Response to Planning Application

From: Arun District Council Greenspace

Application ref: F/7/21/PL

Description: Building a new 1.28 Ha high-tech glasshouse, reservoir and parking area adjacent to the existing 6 Ha glasshouse, reservoir and nursery area. This site is in CIL Zone 3 (Zero Rated) as other development.

Drawing Title
Proposed Site Extension

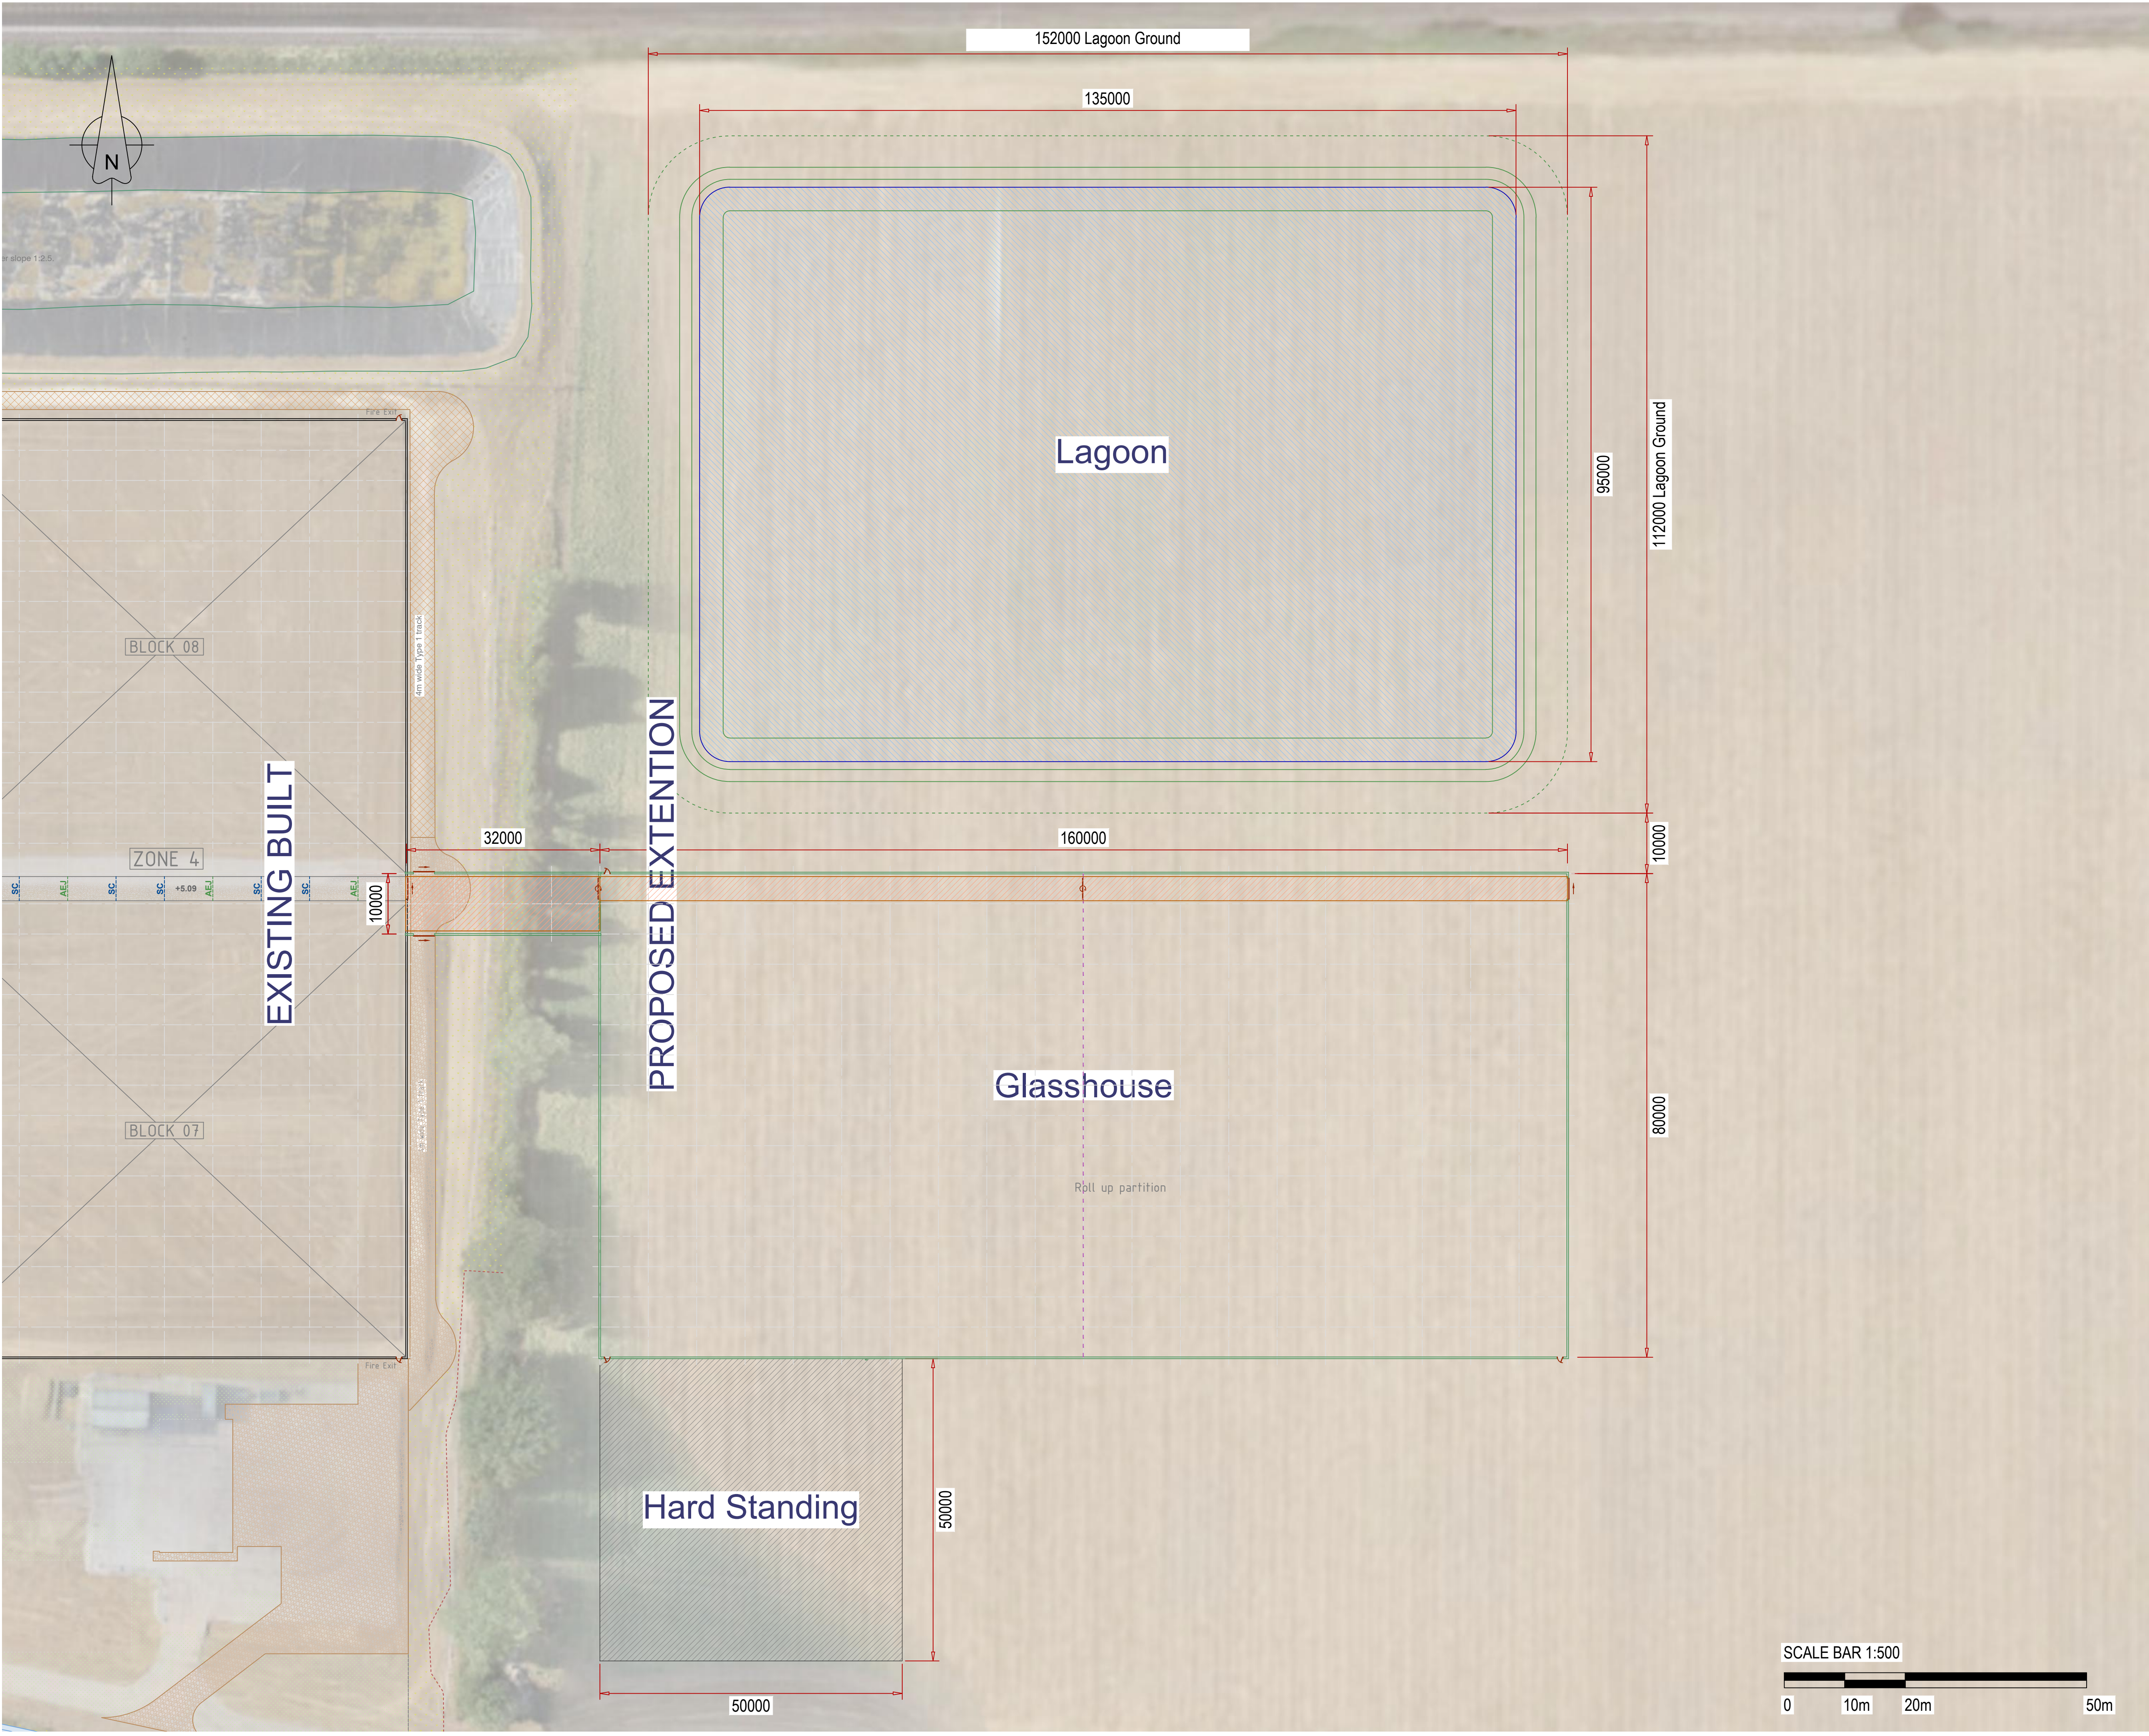
The site is located adjacent to existing commercial greenhouses and horticultural buildings. The site has been subject to an LVIA which has assessed the landscape impact of the proposals on its surroundings. Whilst the proposals would be in line with the surrounding structures and usage it should be noted that the inclusion of landscape mitigation needs to be shown, particularly to screen along the site boundaries.

Native tree and shrub planting should be included both as screening for biodiversity habitat formation and as an offset for the loss of open ground for habitat and foraging.

The proposals would require that mitigation screening landscaping be provided with details shown in plan for detailing species choice, plant quantities, densities and size at time of planting. Landscaping would be required to increase biodiversity and habitat within this rural site.
